**RE: Grading and Drainage Plan Lot 3A, Block 14 Fairgrounds Addition (K18-D27)
Dated August 28, 2001 and Letter dated September 10, 2001**

RE: Lot 3A, Block 14, Fairgrounds Addition (K18-D27)

RE: Grading and Drainage Plan for Lot 3A, Block 14 Fairgrounds Addition (K18-D27)
Dated August 31, 2001

LOT 3A, BLOCK 14,
FAIRGROUNDS ADDITION
GRADING & DRAINAGE PLAN

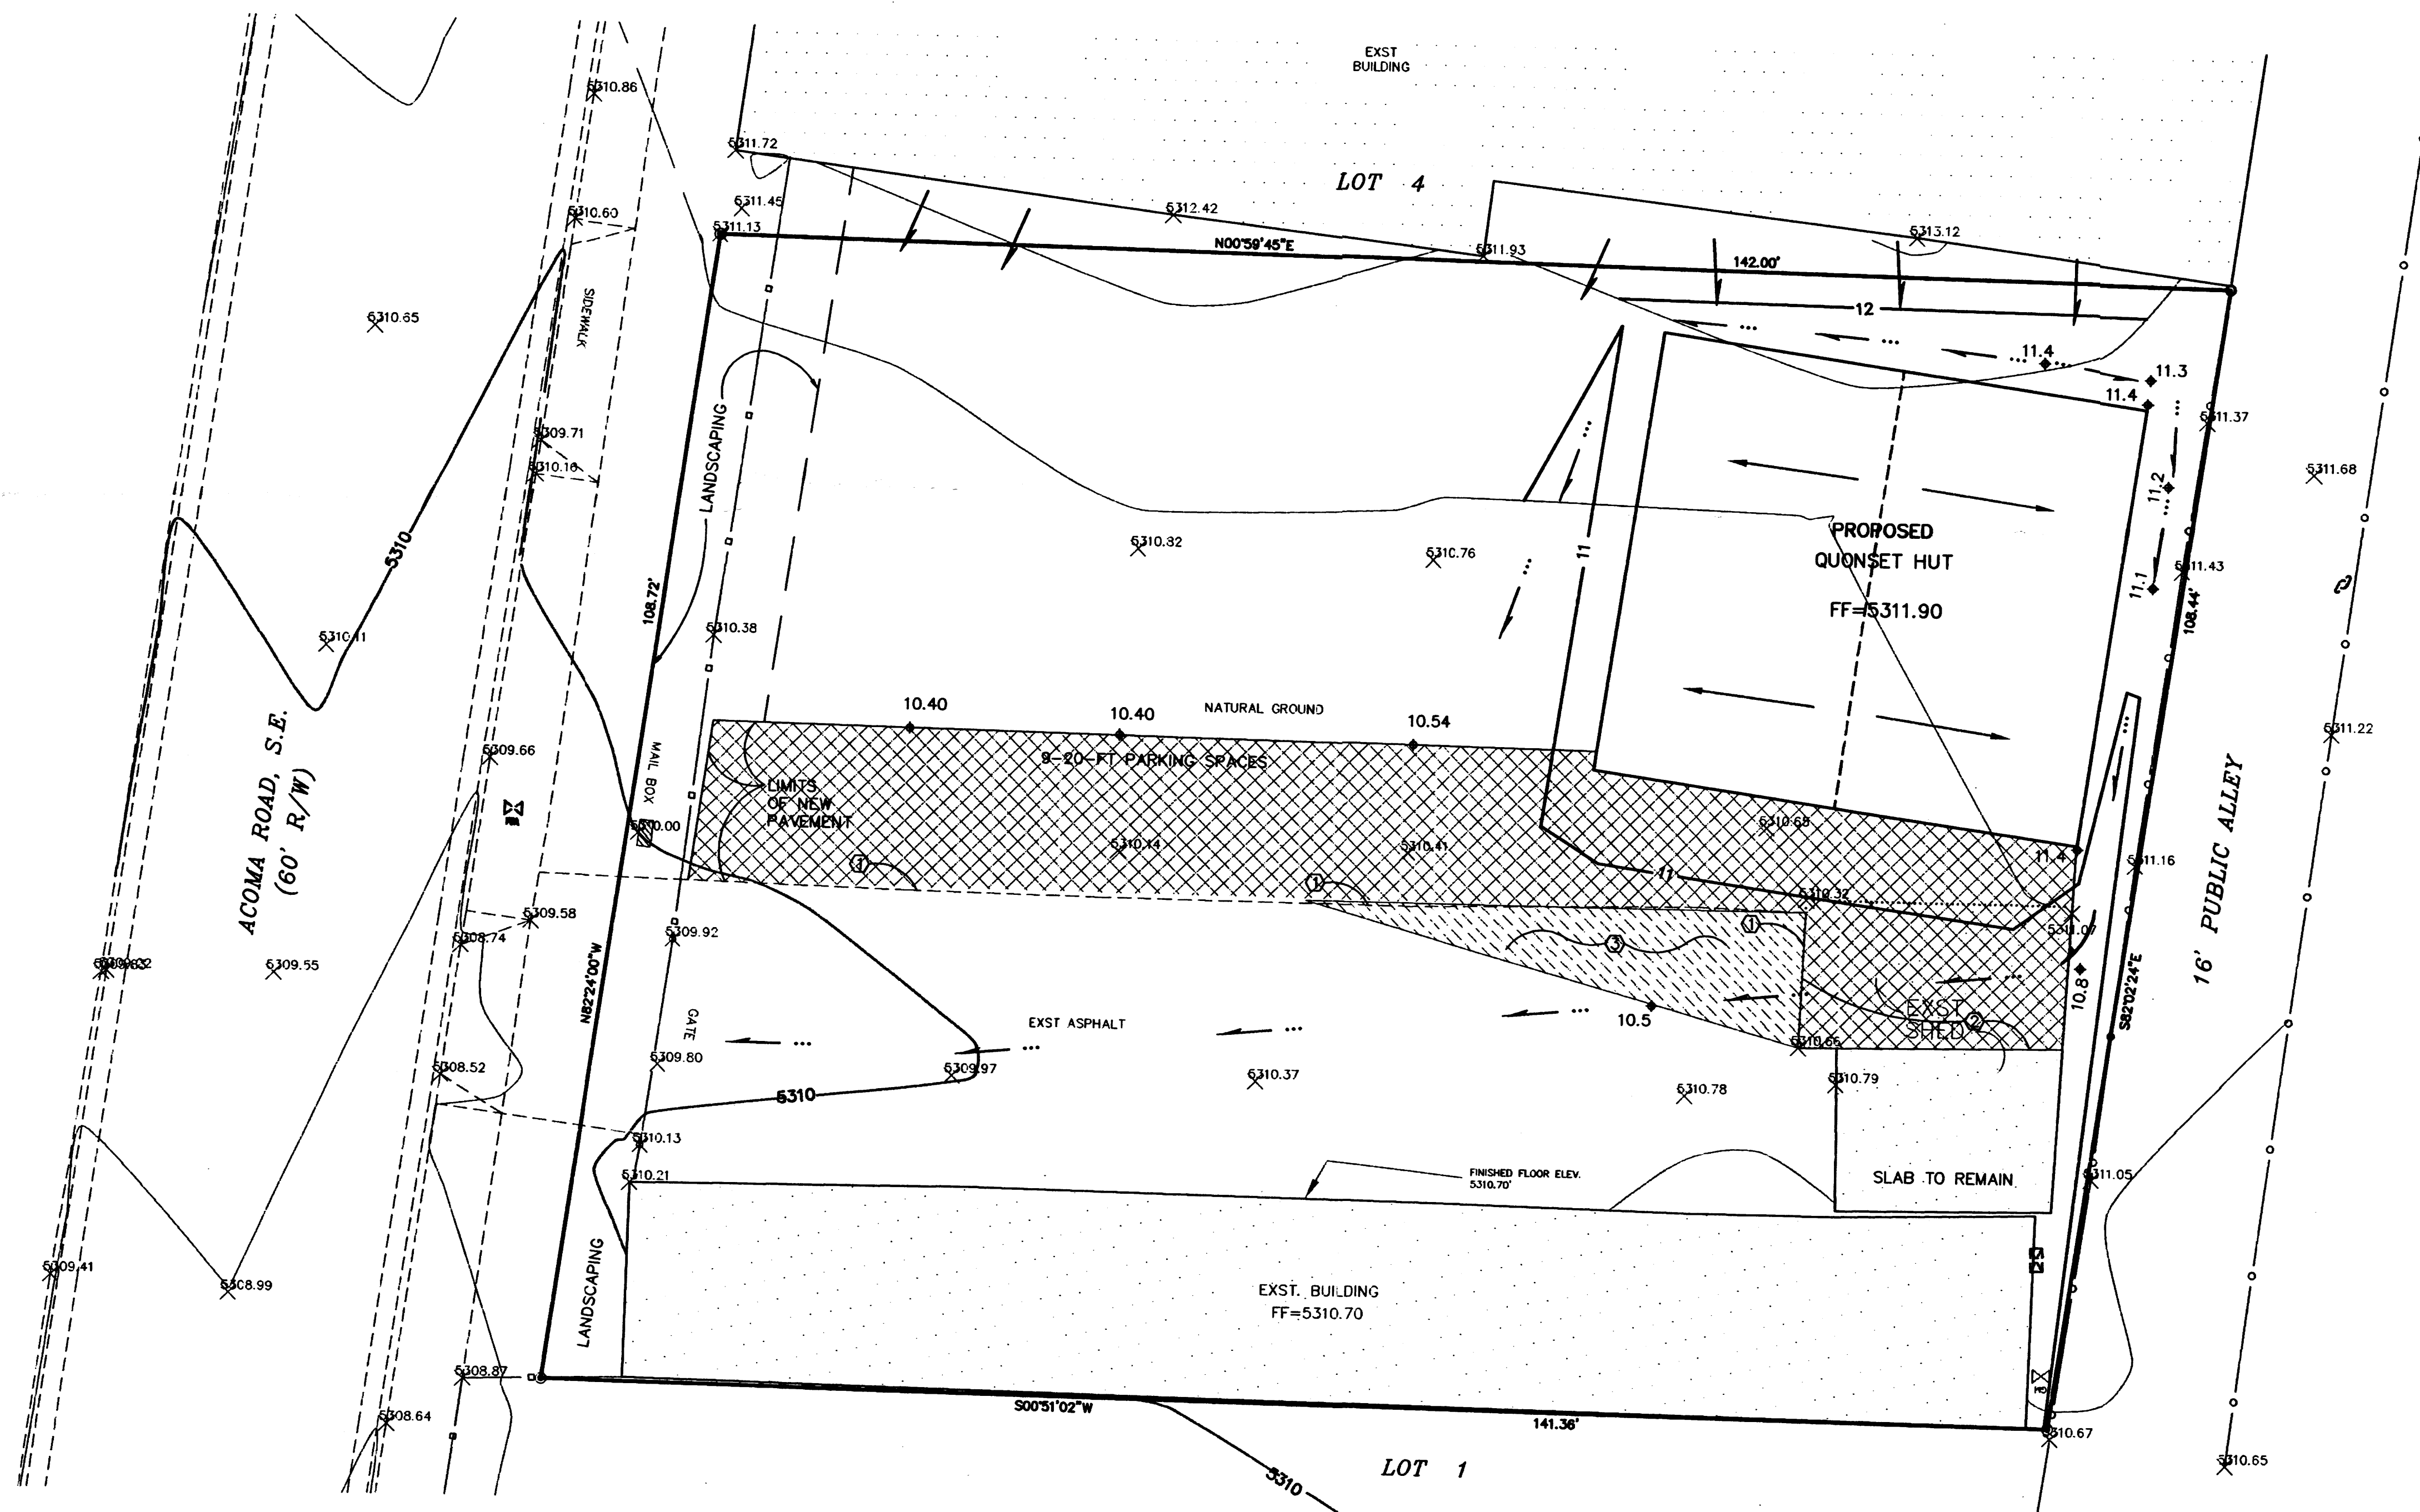
1. Does the property use the public alley for access?
2. Does runoff from the lot discharge to the alley or does the alley discharge into the lot?
3. Is the public alley paved?

1. The public alley is not used for access. An existing fence runs along the site's south property line and no modifications are proposed to this fence.
2. Site runoff discharges to the north, through the drivepad onto Acoma Road SE. It appears that alley runoff flows westward and is prevented from crossing onto the site by debris which has collected along the bottom of the chainlink fence.
3. The alley is paved but is in poor condition with weeds growing through the asphalt in places.
